SSD DA 9594 - WEST WYALONG

Reference is made to the Department's recent correspondence regarding the application including a request to provide additional information/clarification as well as changes to several maps. In response to this request, please find enclosed the following:

**APPENDIX 4
ROAD UPGRADES AND SITE ACCESS**

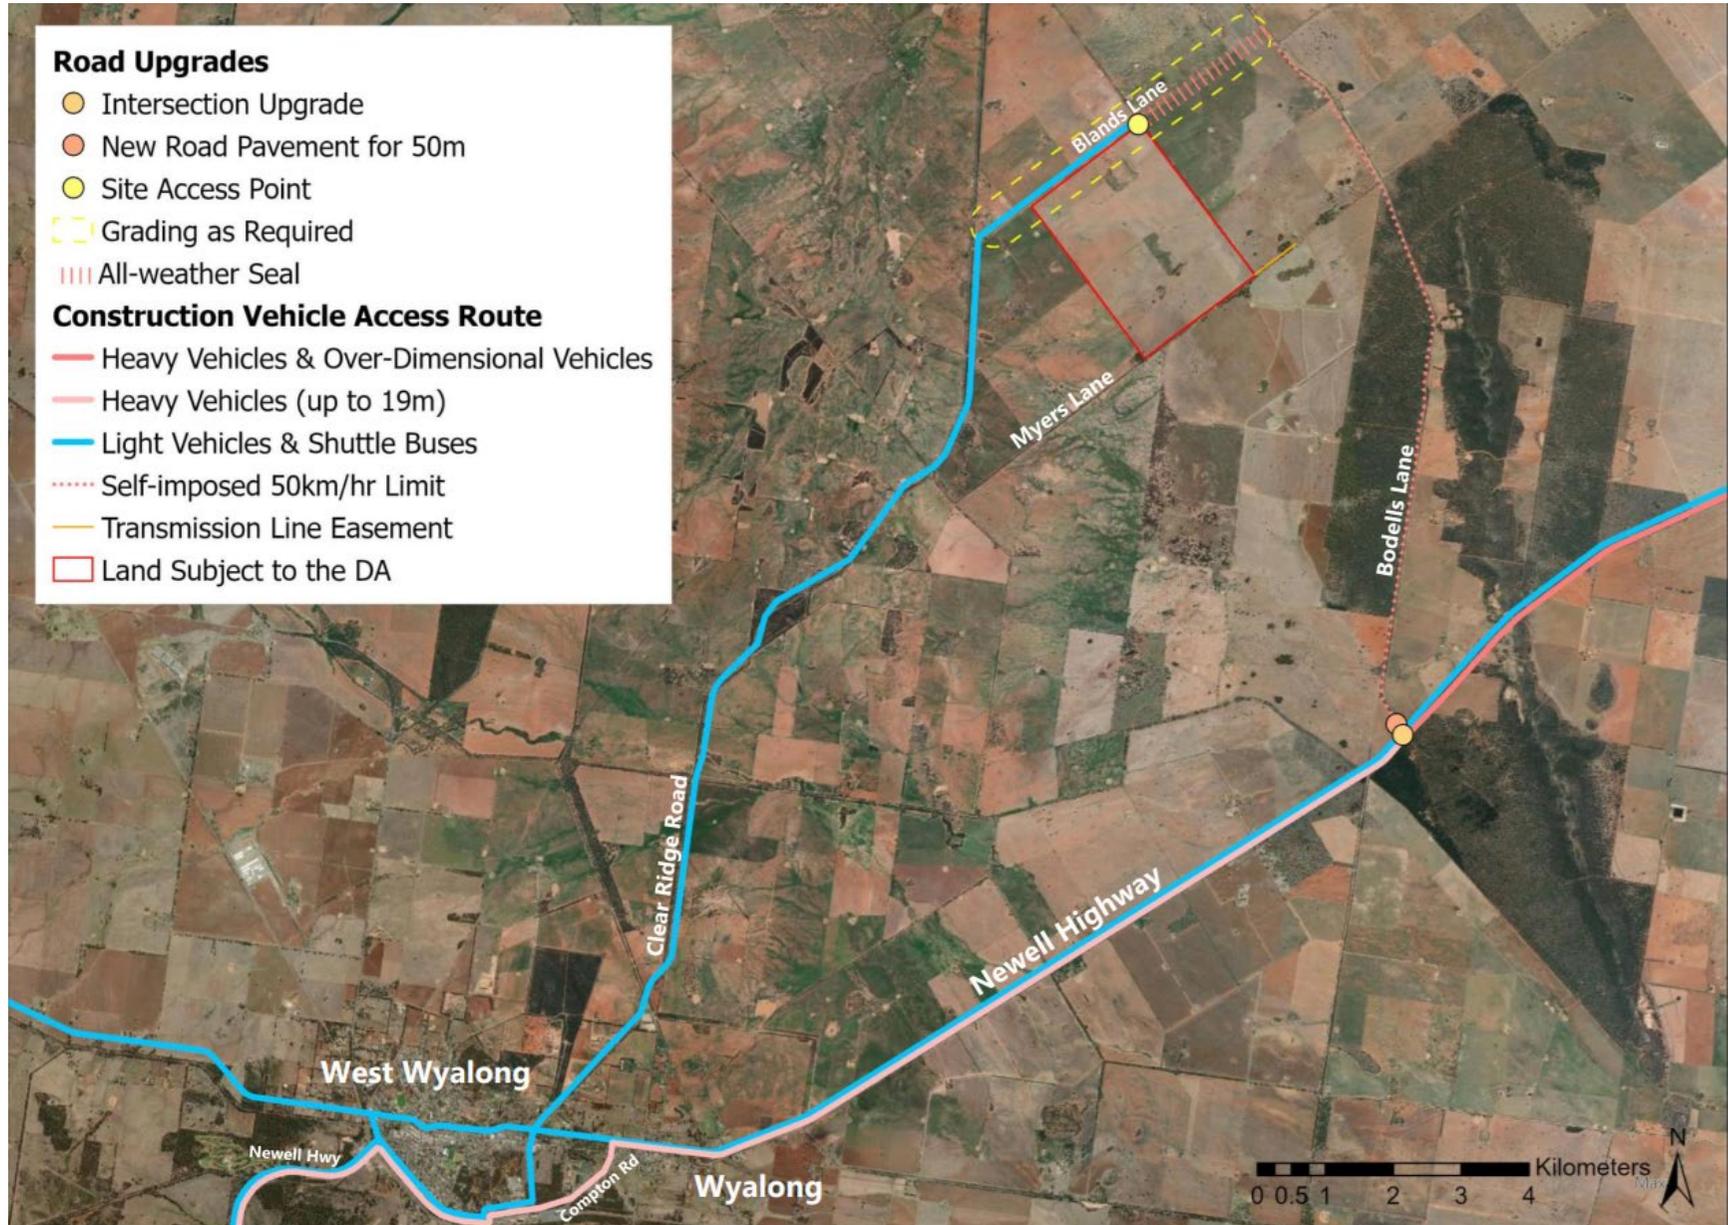
c) Revised Site Access Map

The amended map includes:

- Transmission lines, including the transmission line to which the Project will connect;
- The portion of Myers Lane in the 'Land subject to the DA'; and
- Myers Lane has been labelled.

APPENDIX 1
GENERAL LAYOUT OF DEVELOPMENT

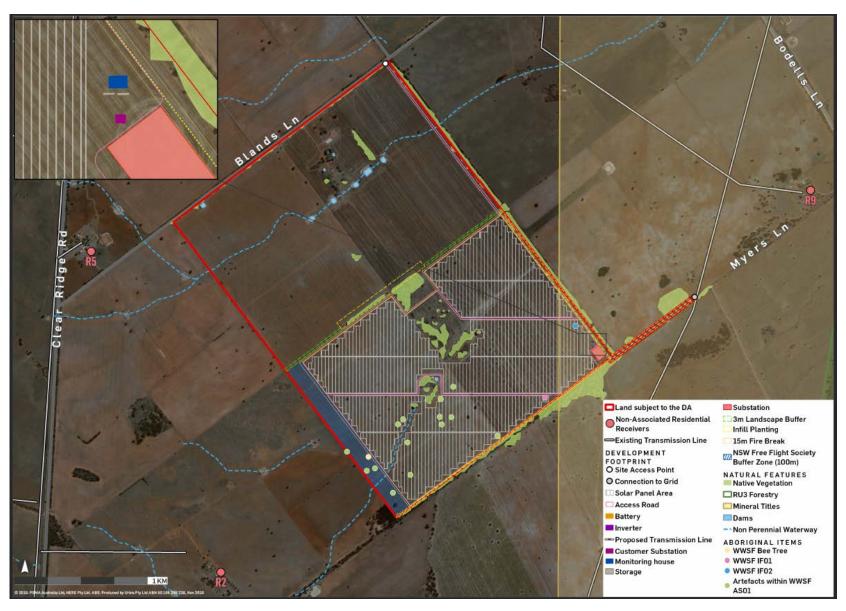
d) Revised Site Constraints Map

The amended map includes:

- The scale of the map been decreased while including R2, R4, R5 and R9;
- R10 has been removed;
- The project boundary has been amended to be clearly visible around the whole of the Project site;

- All layers have been made more visible;
- The vegetation buffer is within the Project site boundary;
- Infill planting is proposed along Myers Lane;
- The site access point dot has been removed;
- The 'High Ecological Constraint' and 'Moderate Ecological Constraint' vegetation labels have been combined and added to the existing 'Native Vegetation' label;
- The access track located in the centre of the site does not overlap with the patch of native vegetation to be retained; and
- The legend has been amended and includes sub-headings for those items that can be grouped together.

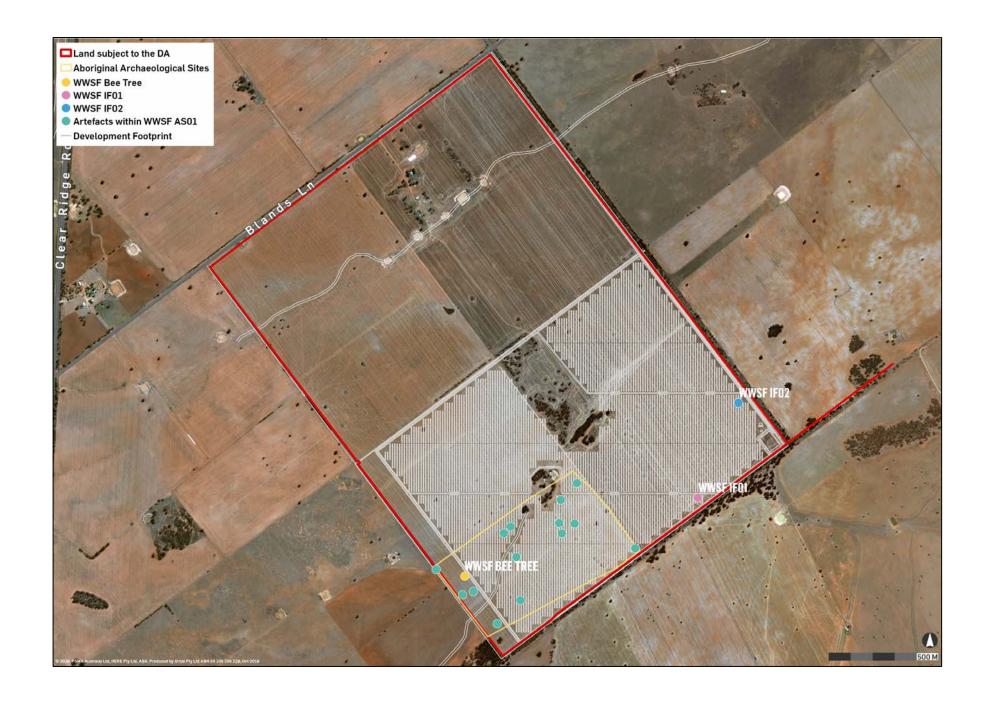
b) Revised Aboriginal Cultural Heritage Map

The amended map includes:

- The whole of the Project site.
